24 November 2015

Our Reference: SYD15/00637/02 (A10763543)  
Department Ref: SSD 7064

**HOTEL & RESIDENTIAL DEVELOPMENT**  
175-177 CLEVELAND STREET & 1-5 WOODBURN STREET, REDFERN

**DA2007 A**

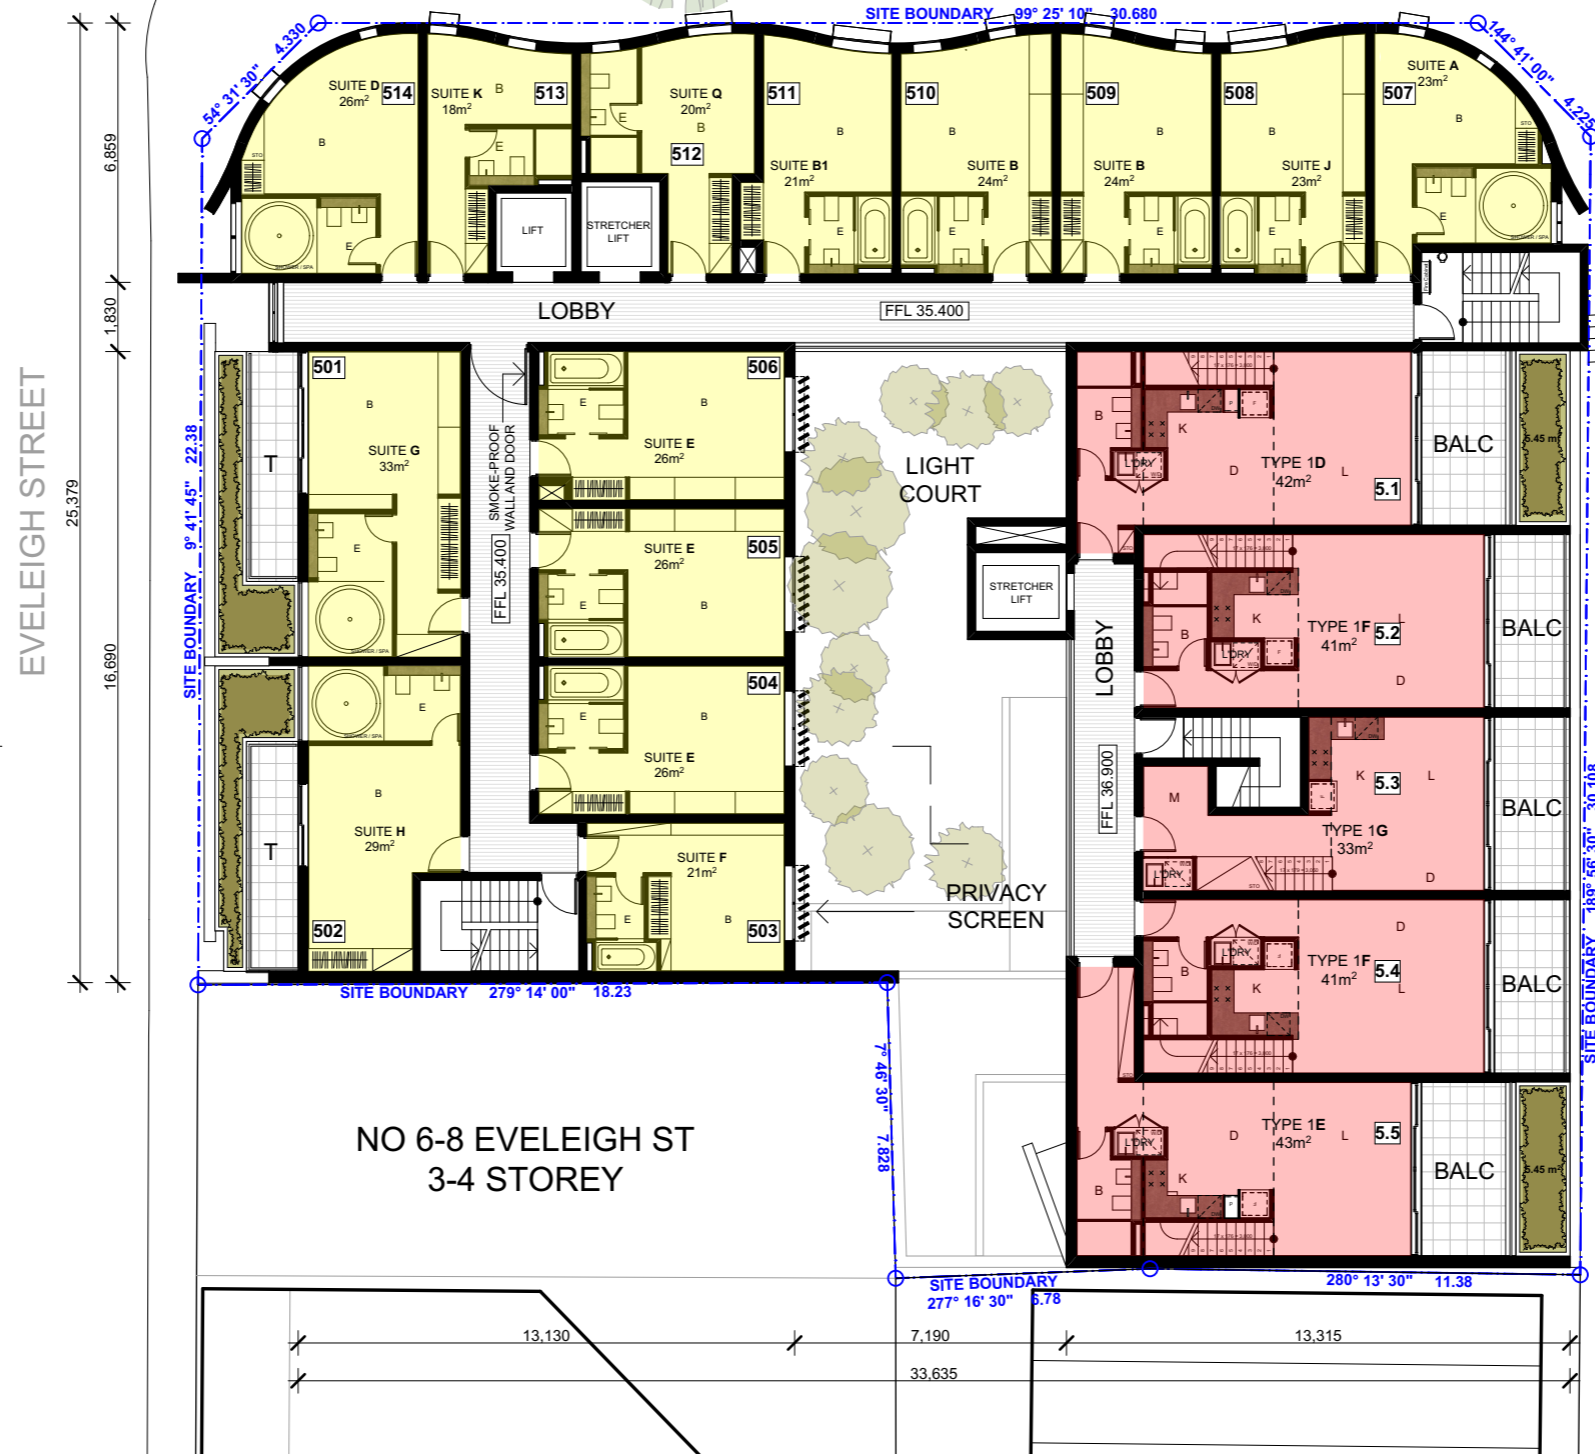
1. Roads and Maritime has previously dedicated a strip of land as road along the Cleveland Street frontage of the subject property as shown by grey colour on the attached Aerial – "X"

Therefore all buildings and structures other than pedestrian footpath awnings together with any improvements integral to the future use of the site are to be wholly within the freehold property unlimited in height or depth along the Cleveland Street boundary.
